Our Case Number: ABP-314724-22

Re: Railway (Metrolink - Estuary to Charlemont via Dublin Airport) Order [2022]
Metrolink. Estuary through Swords, Dublin Airport, Ballymun, Glasnevin and City Centre to Charlemont,
Co. Dublin

Re: Railway (Metrolink–Estuary to Charlemont via Dublin Airport) Order 2022

I am writing with regard to the proposed development of a Terminus for the MetroLink project at Charlemont, Dublin 6, under the Railway Order 2022

CHARLEMONT STATION

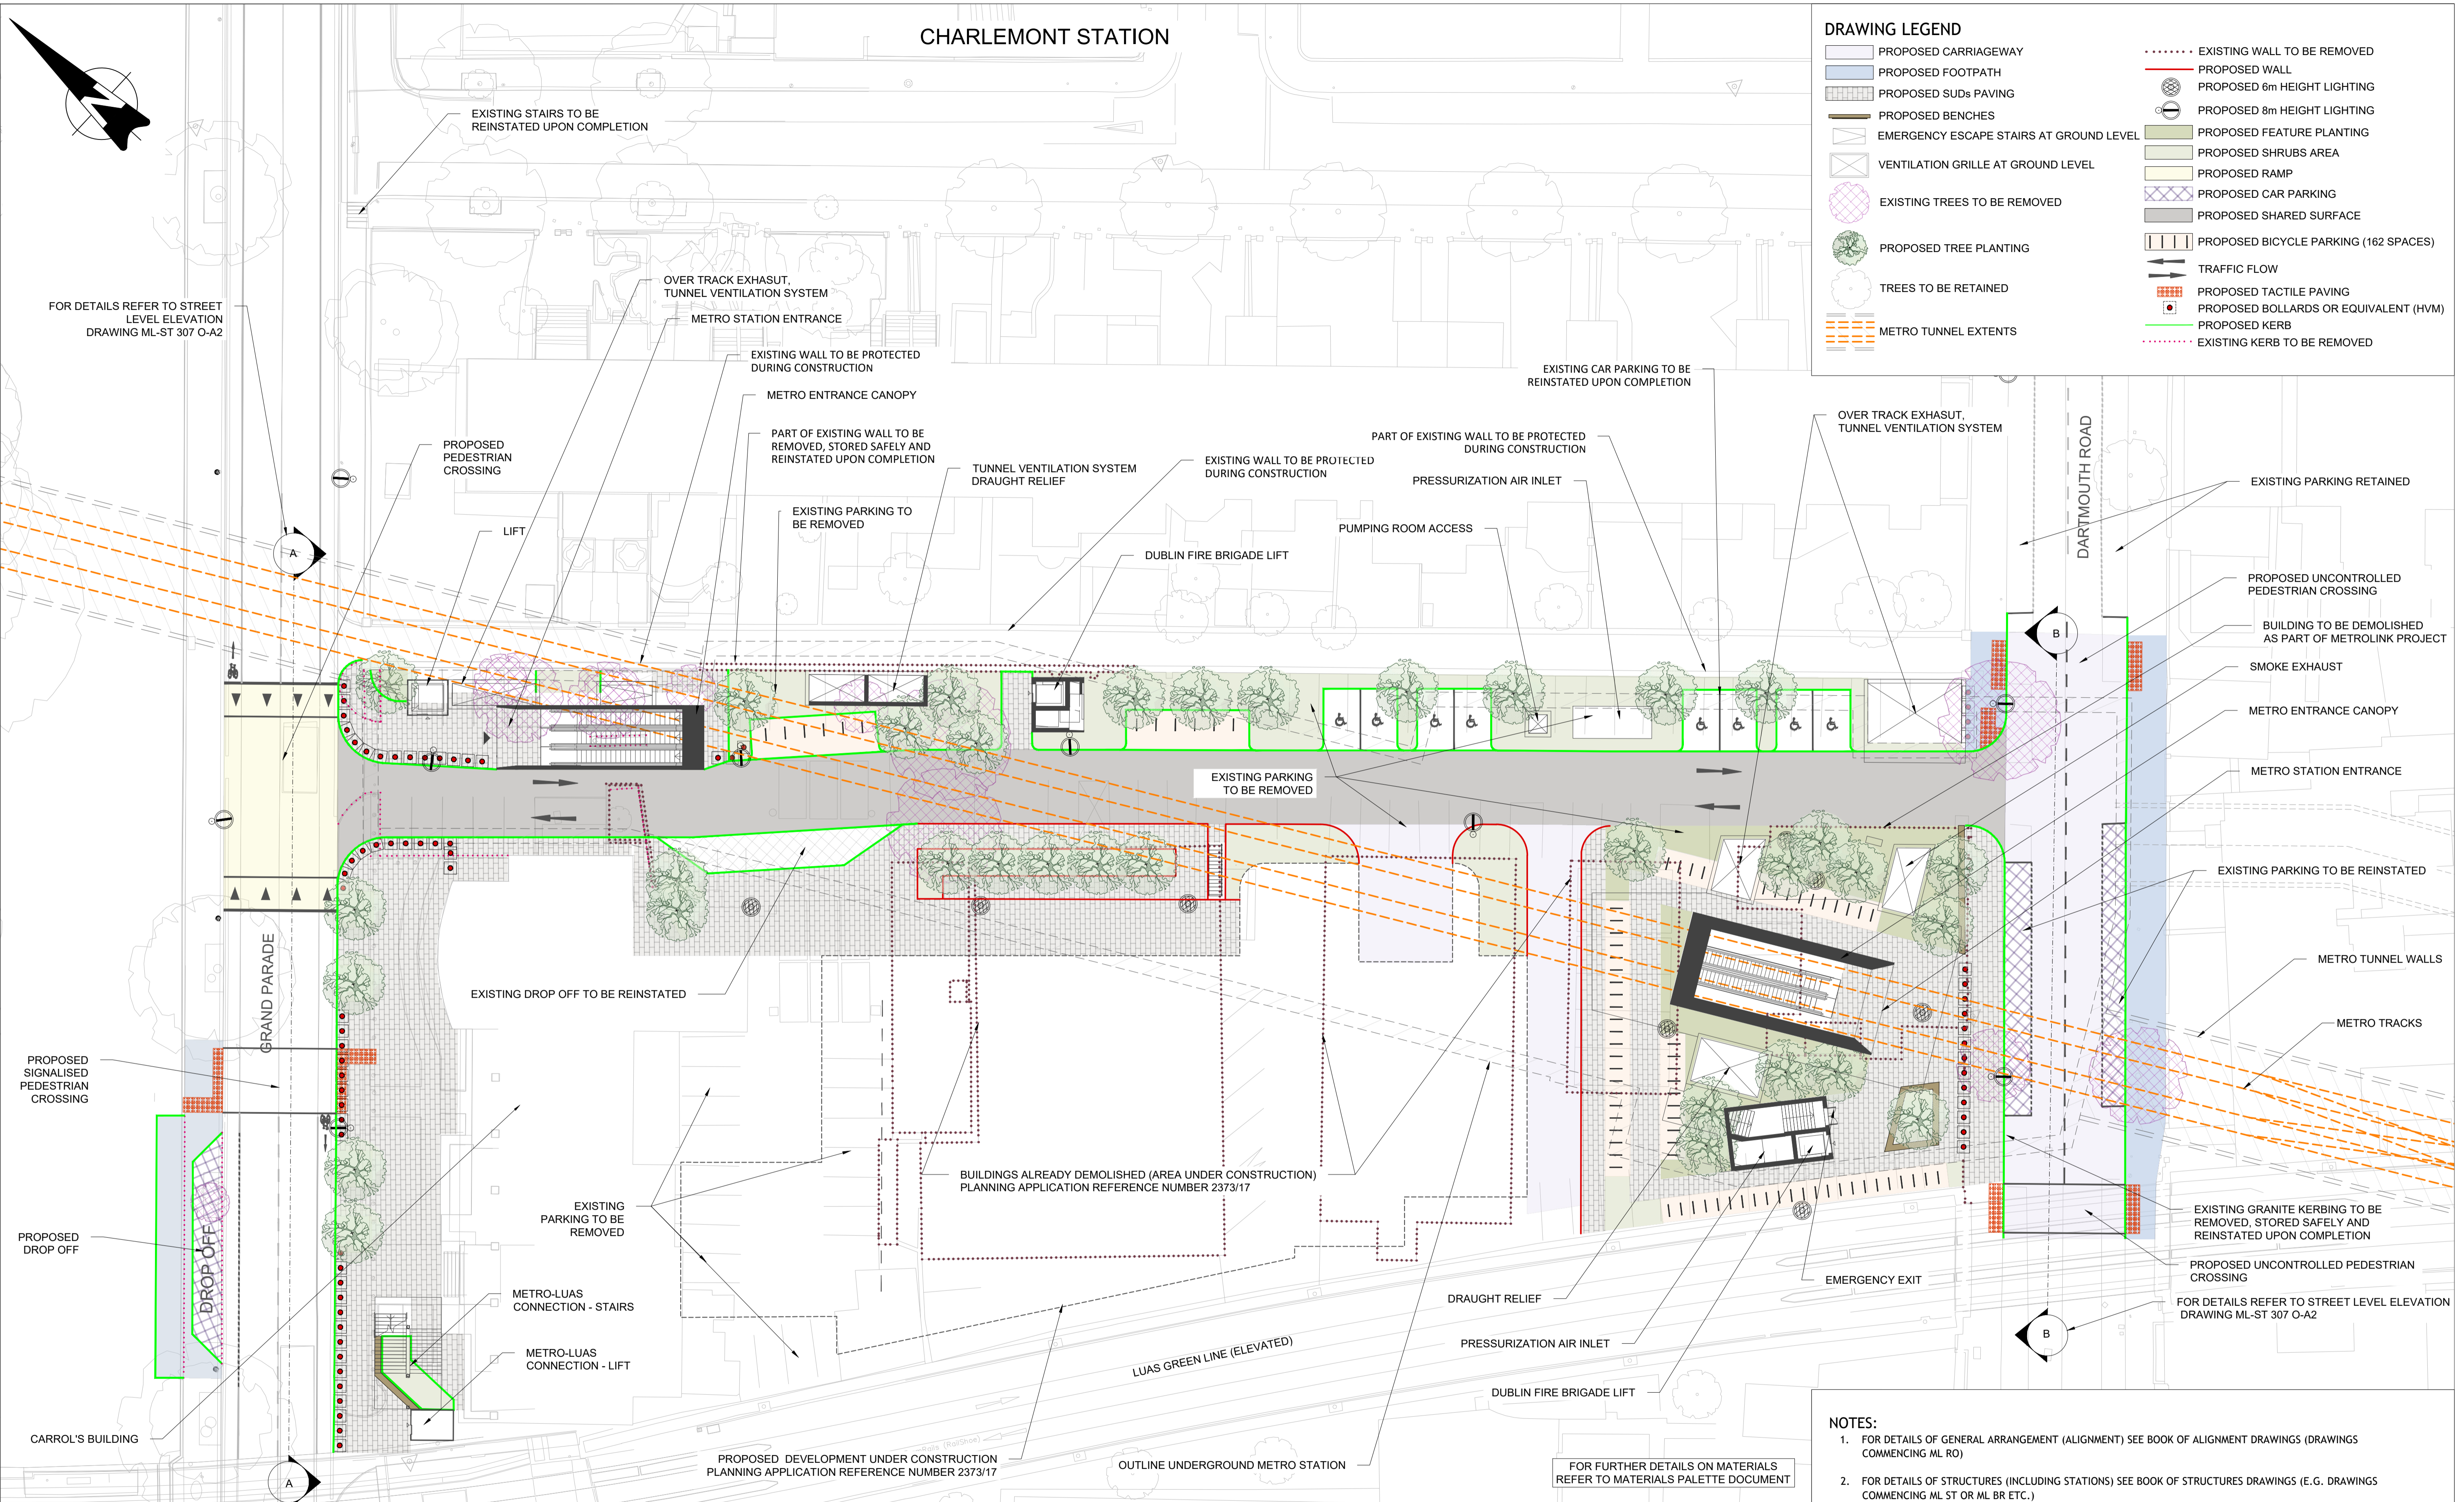
No. 1 Dartmouth Square, my property, will be affected by the location of the vast Southern Entrance Plaza and the Tunnel Ventilation Exhaust ducts located behind the boundary wall.

Item 15 Metro Over Track Exhaust - Tunnel Ventilation System located behind No. 1 Dartmouth Sq.

Charlemont Metro Station Plaza - South Entrance located at rear of No. 1 Dartmouth Square .

CHARLEMONT STATION - LONGITUDINAL SECTION
1 : 200

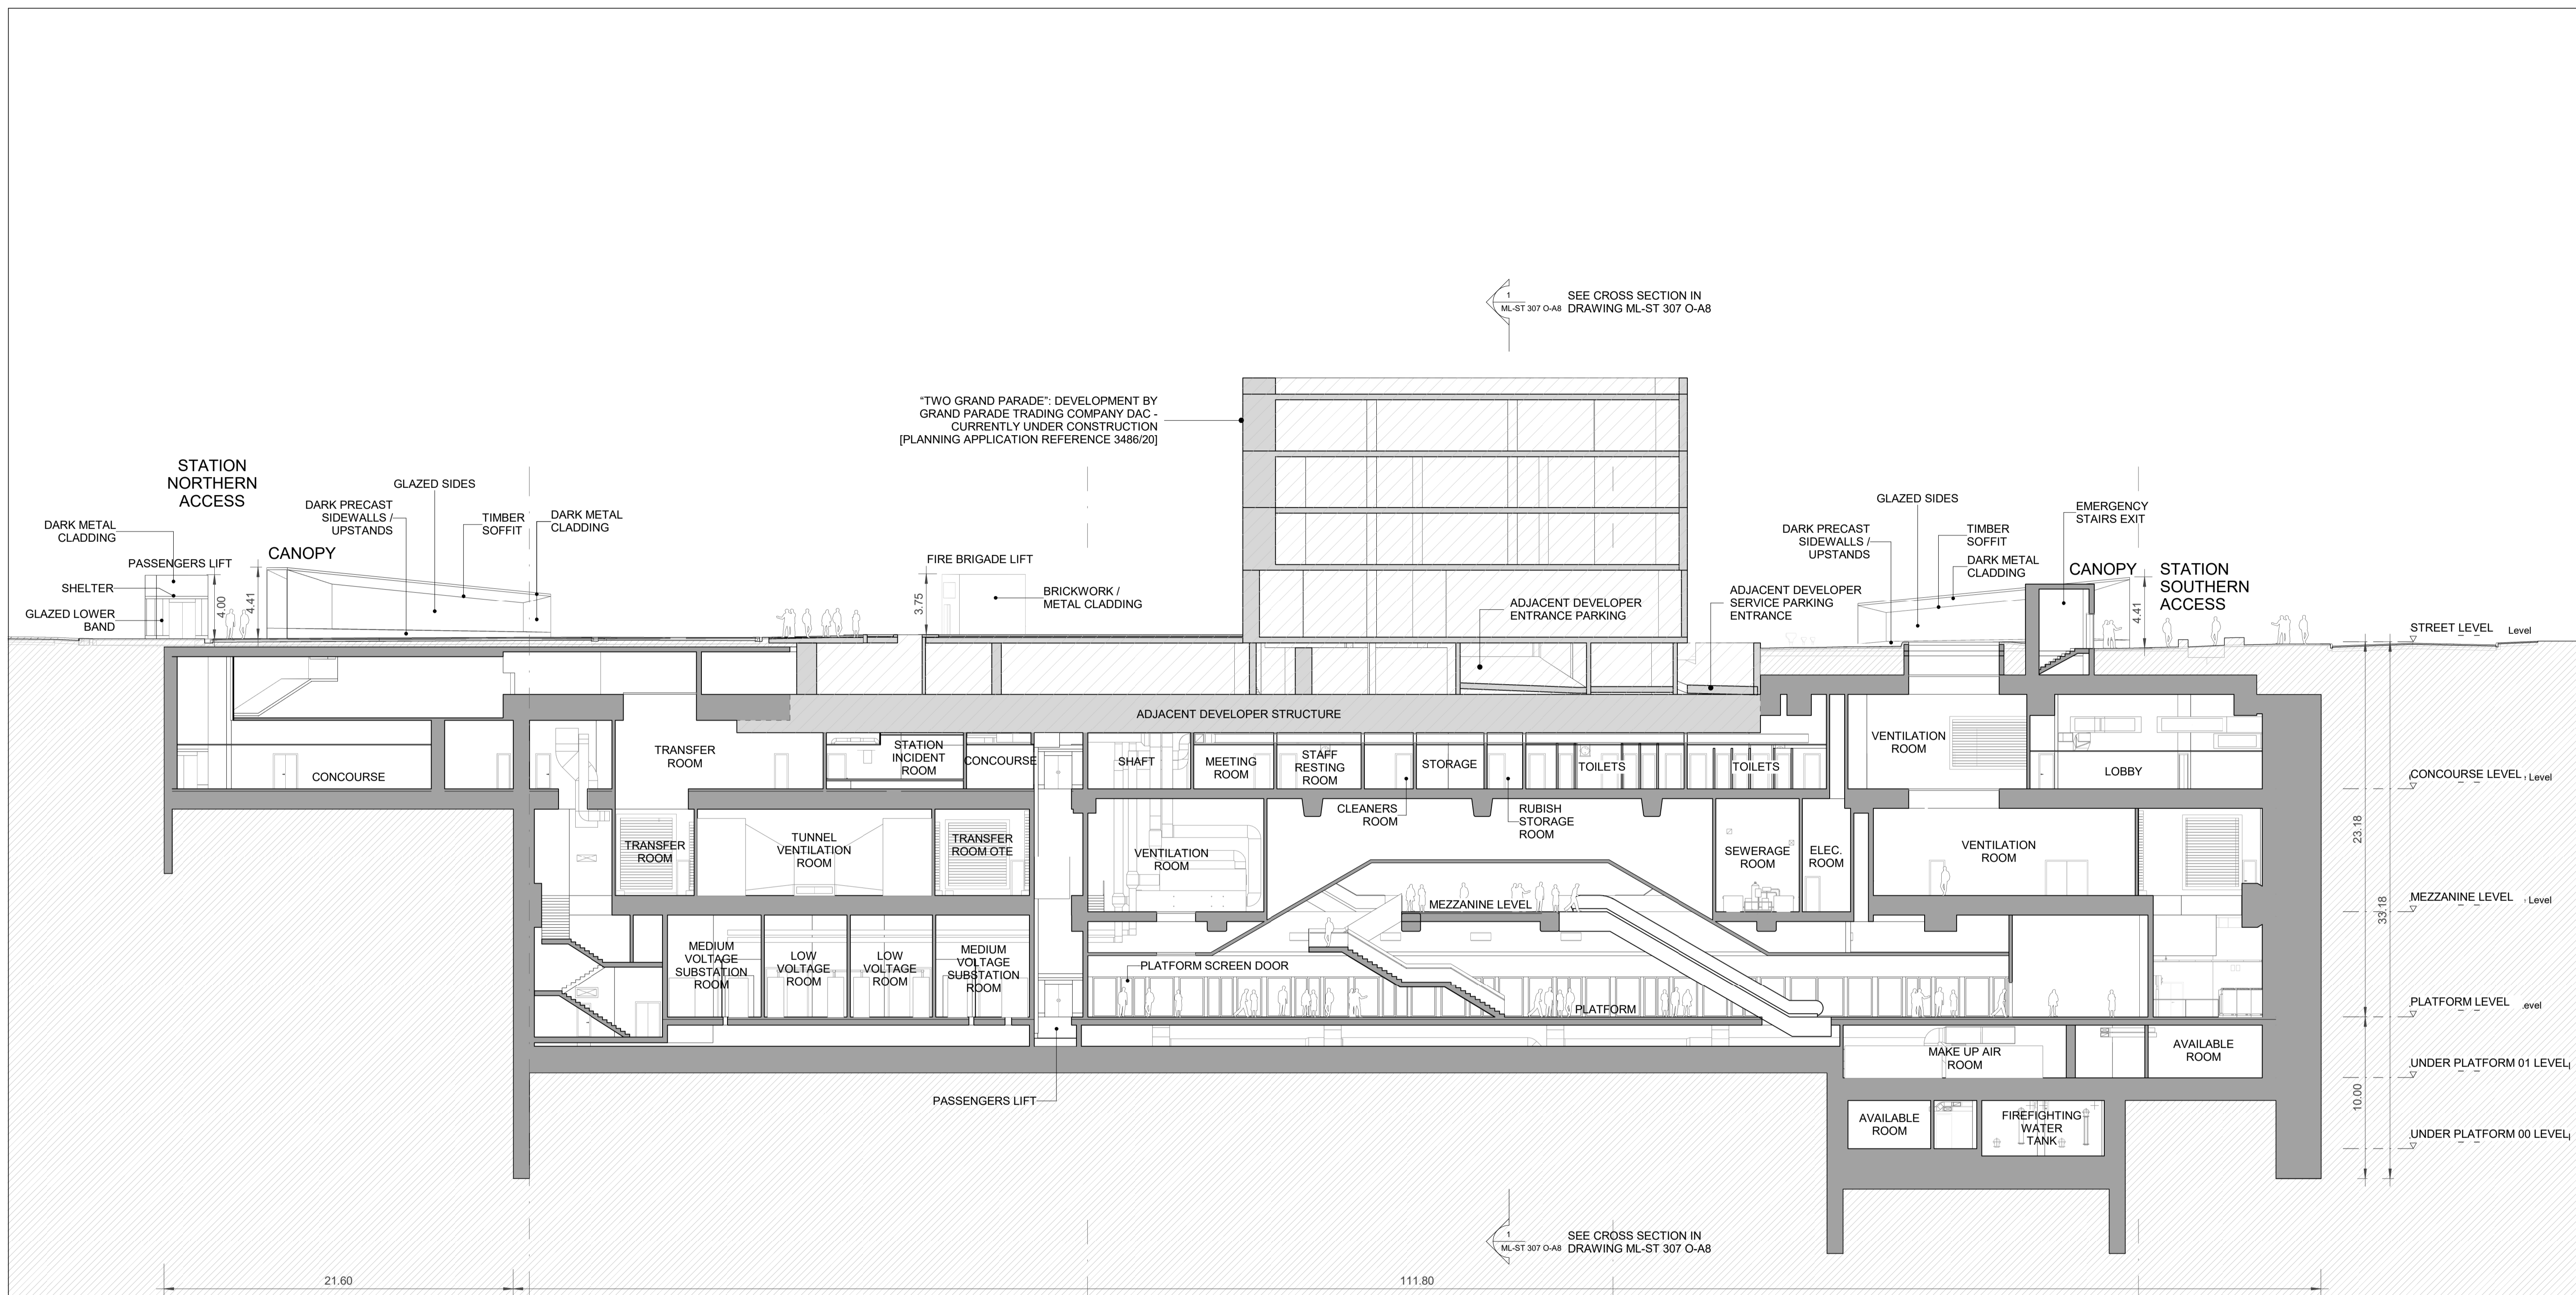
- The deep construction required immediately adjacent to residential houses is wholly inappropriate and will result in a very severe loss of amenity and devaluation of property.

- The EIAR fails to properly assess the settlement impacts of the tunnelling upon the houses on Dartmouth Square West and there may be settlement of between 10mm and 30 mm which would severely affect these protected buildings.

3. The deep construction proposed to construct the Charlemont Terminus Station immediately adjacent to residential houses is wholly inappropriate and will result in a very severe loss of amenity and devaluation of property.
